Our Ref: BE/55/18/PL
Your Ref:

Town & Country Planning Act 1990 (as amended)
Town & country Planning (Development Management Procedure) (England) Order 2015
Application for Planning Permission for Works or Extension to a Dwelling

Development Erection of double garage (resubmission following BE/15/17/PL). This application affects the setting of a listed building & may affect the character & appearance of the North Bersted Conservation Area.

Location Rear of 95-99 North Bersted Street Bersted

CLIENT	PROJECT	TITLE	STATUS	DRAWN BY	REVIEWED BY
C. TOMKINS	REAR OF 99 NORTH BERTSD STREET	PROPOSED GARAGE	PLANNING	SJ	SJ
			DATE	SCALE	DRAWING NUMBER
			19.04.18	1:500A3	8A

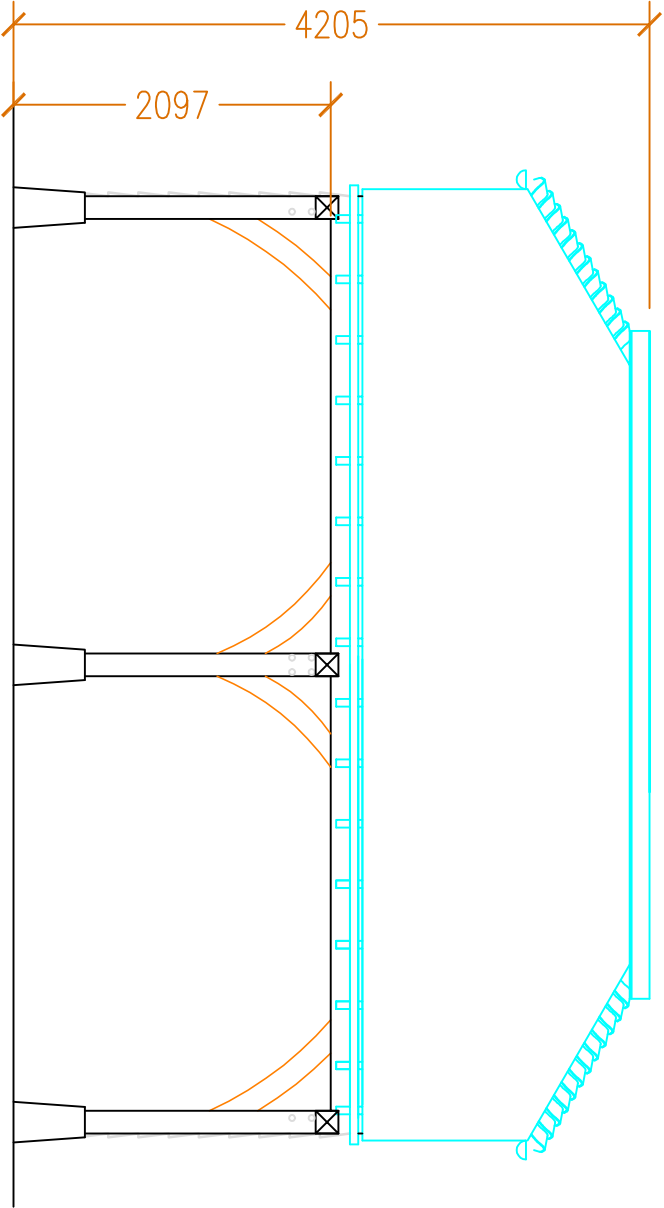
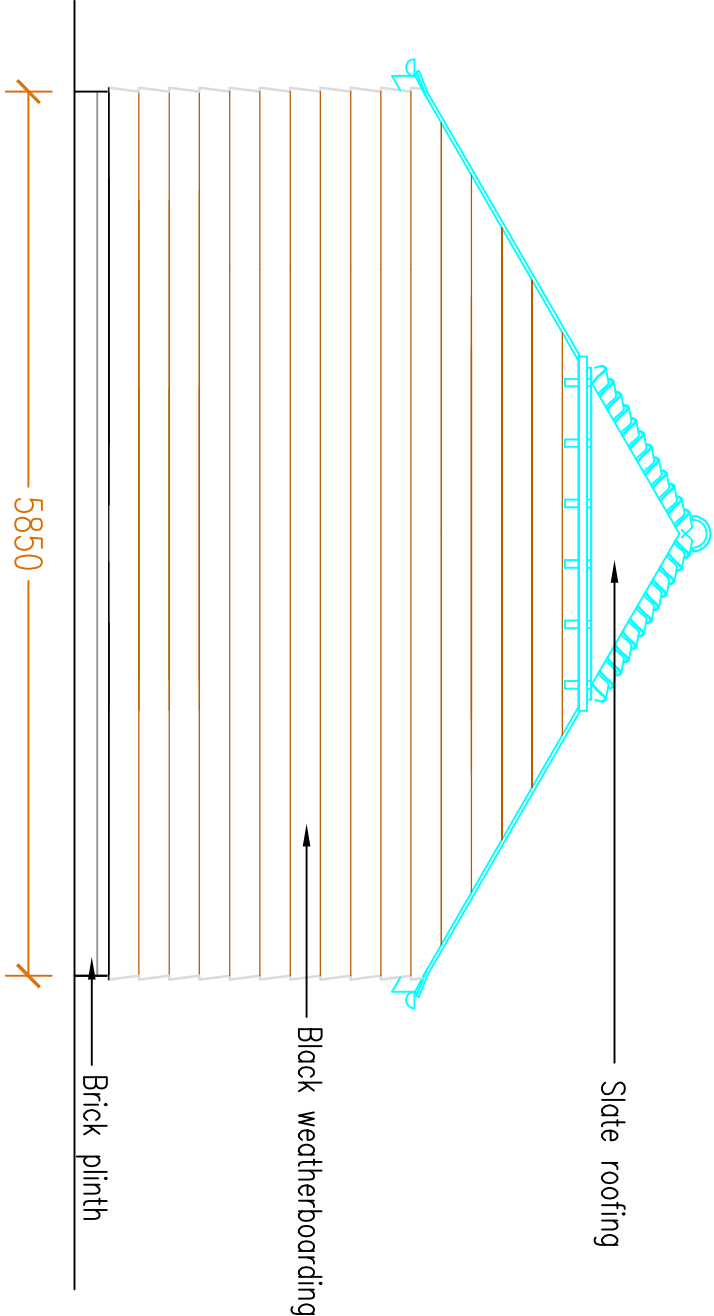
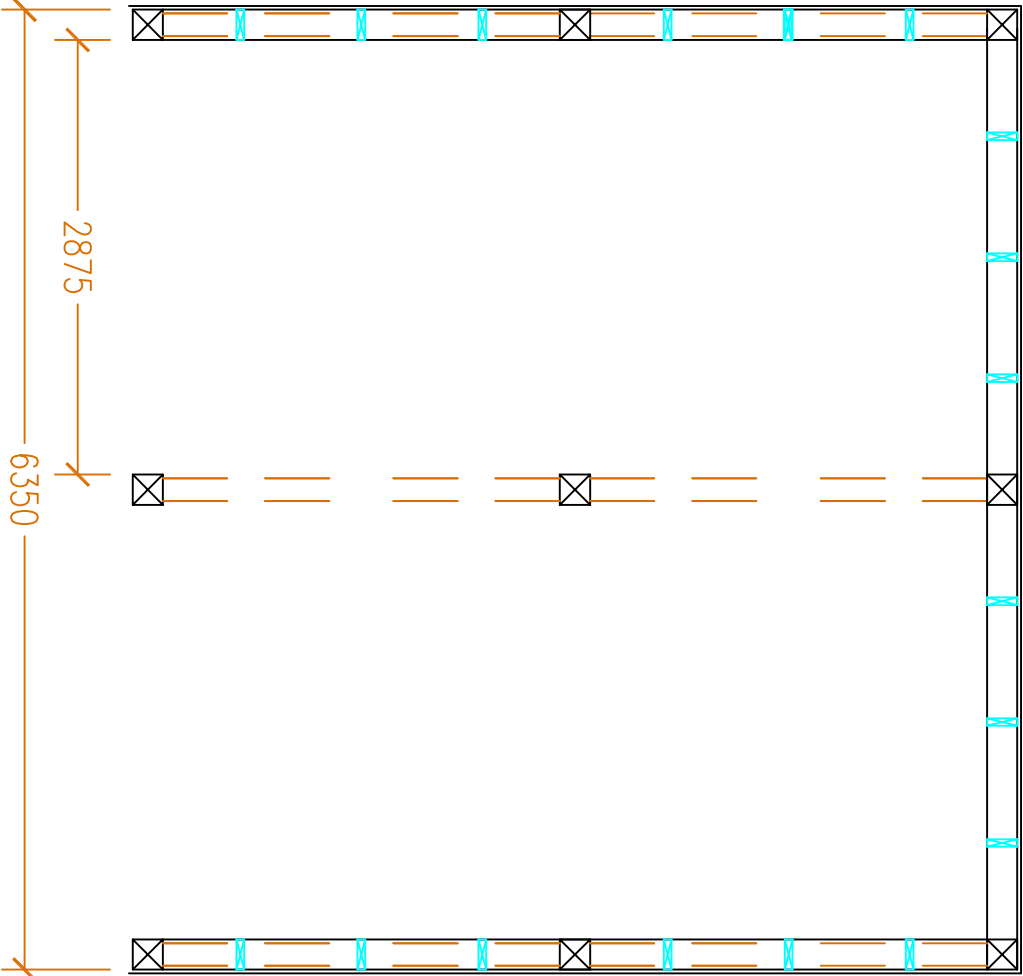
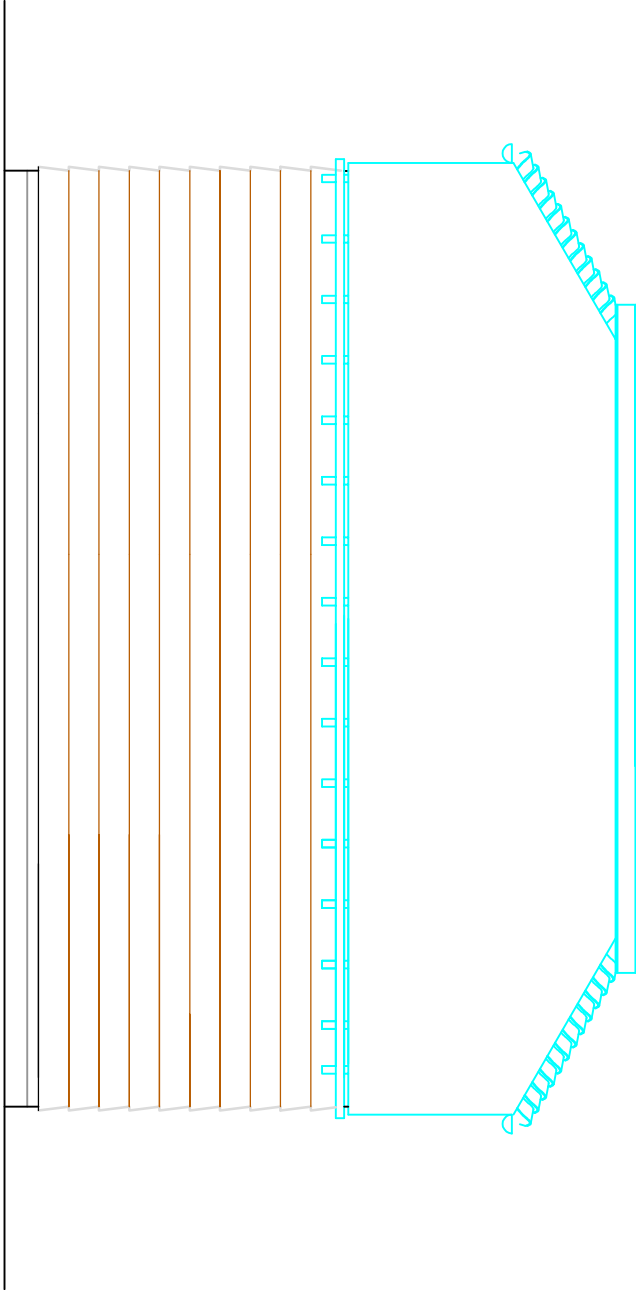
Plan 8A indicates a scale of 1:100 in the legend. The plans do not scale correctly at this scale. Please amend accordingly.
